From: Daniel cooper [REDACTED]
Sent: 03 August 2021 22:28
To: Kathryn Welch <Kathryn.Welch@arun.gov.uk>
Subject: Re: F/11/21/PL

In response to comments raised by concerned neighbours in Lewis Lane.

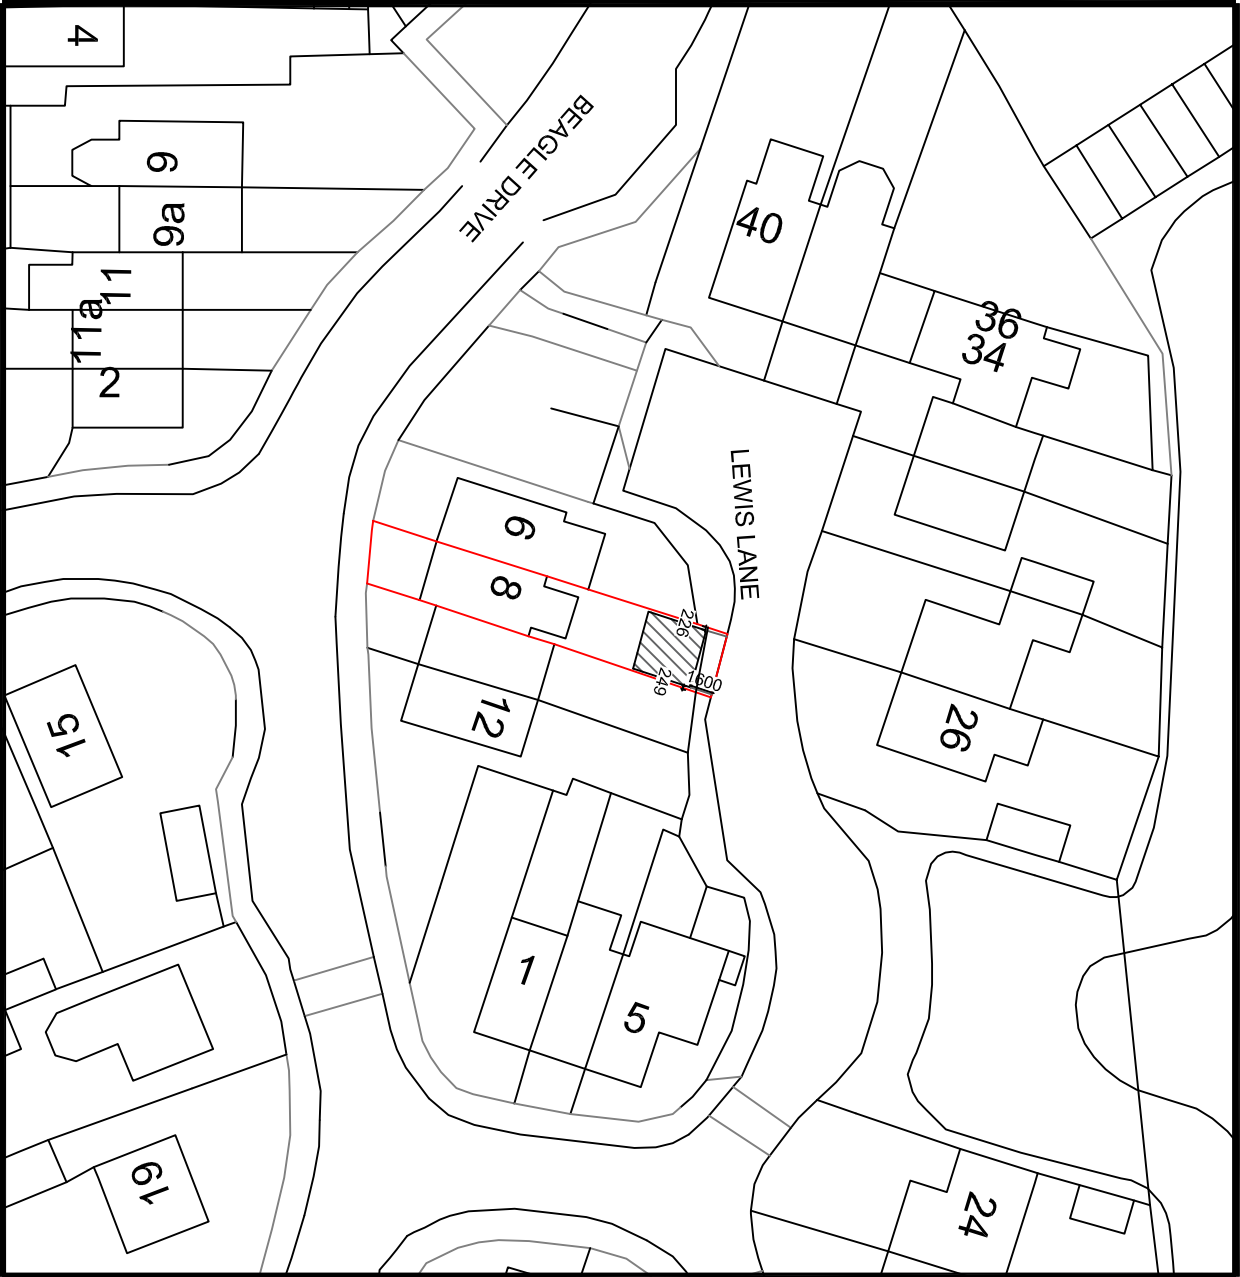
In relation to the highways request. They require a plan showing the existing boundary line with the new boundary line, the google images can be used as supporting evidence but a plan to scale provides the most accurate information and this is needed to determine the size of the strip of land which now forms part of your property. If the garage now forms the boundary this should be annotated to plans.

The advice of the highways is that if a dropped kerb is not intended then the hardstanding will need to be removed. The issue they face is that although you may not wish to use the access for vehicles, future occupants may attempt to because of the hardstanding provision. So what they are trying to achieve is an all or nothing situation, you either go for the dropped kerb, fully licensed or, its removed and then there is no chance of it ever being used as such. This is a decision you will need to take.

historical realignment of the rear boundary fence – does this mean they would like to see the old fence line? Which can I can provide from google maps?

In respect of the “proposed fence position” there will not be a rear fence as the 12ft by 12ft building covers the previous access (acting as a fence)
